Ribble Valley Borough Council
Church Walk,
Clitheroe,
BB7 2RA

Phone: 0300 123 6780
Email: lhscustomerservice@lancashire.gov.uk
Your ref: 3/2015/0484
Our ref: LHS/CS/3/2015/0484
Date: 7th July 2015

Proposal:	Proposed two storey extension to rear with one new roof light on existing dwelling.
Location:	Mill Hey Croft Chatburn BB7 4LD
Grid Ref:	377007 - 444307

Proposed Site Plan

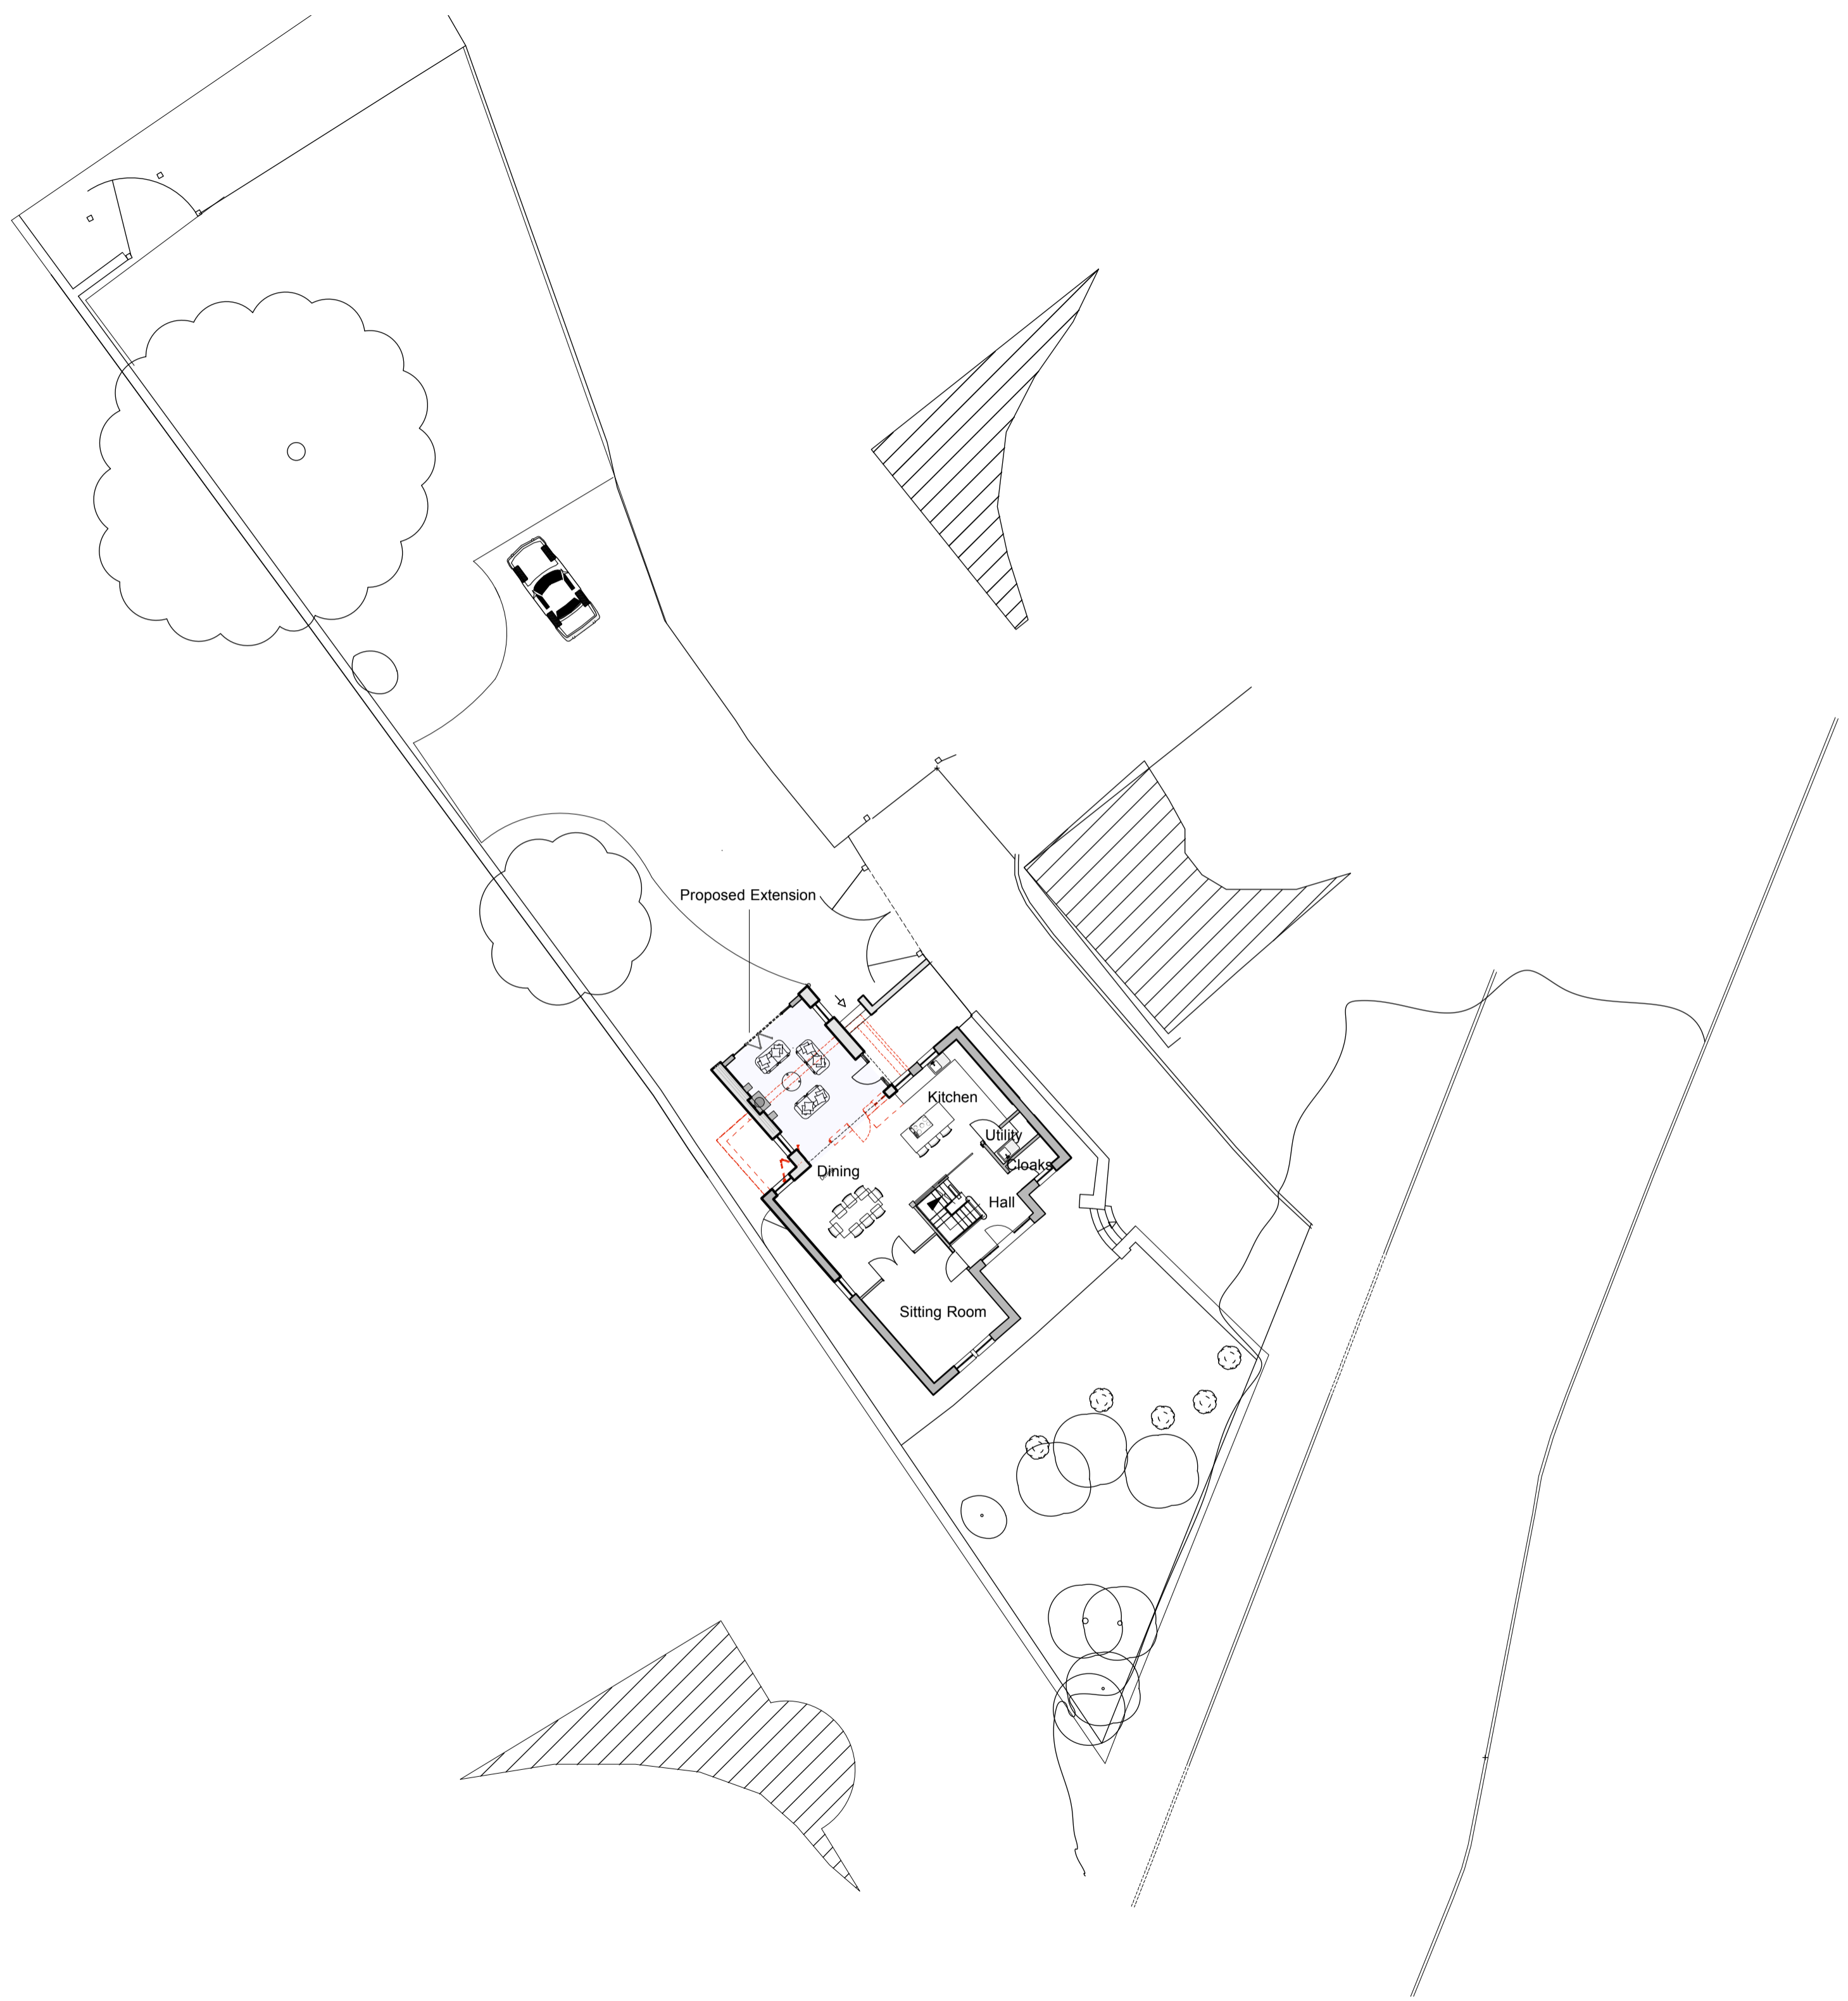
Based on the Joint Lancashire Structure Plan the Highway Development Control Section are of the opinion that the applicant has provided adequate off road parking provision for this type and size of development.

1. The car parking and manoeuvring scheme to be marked out in accordance with the approved plan, before the use of the premises hereby permitted becomes operative and permanently maintained thereafter. Reason: To allow for the effective use of the parking areas.
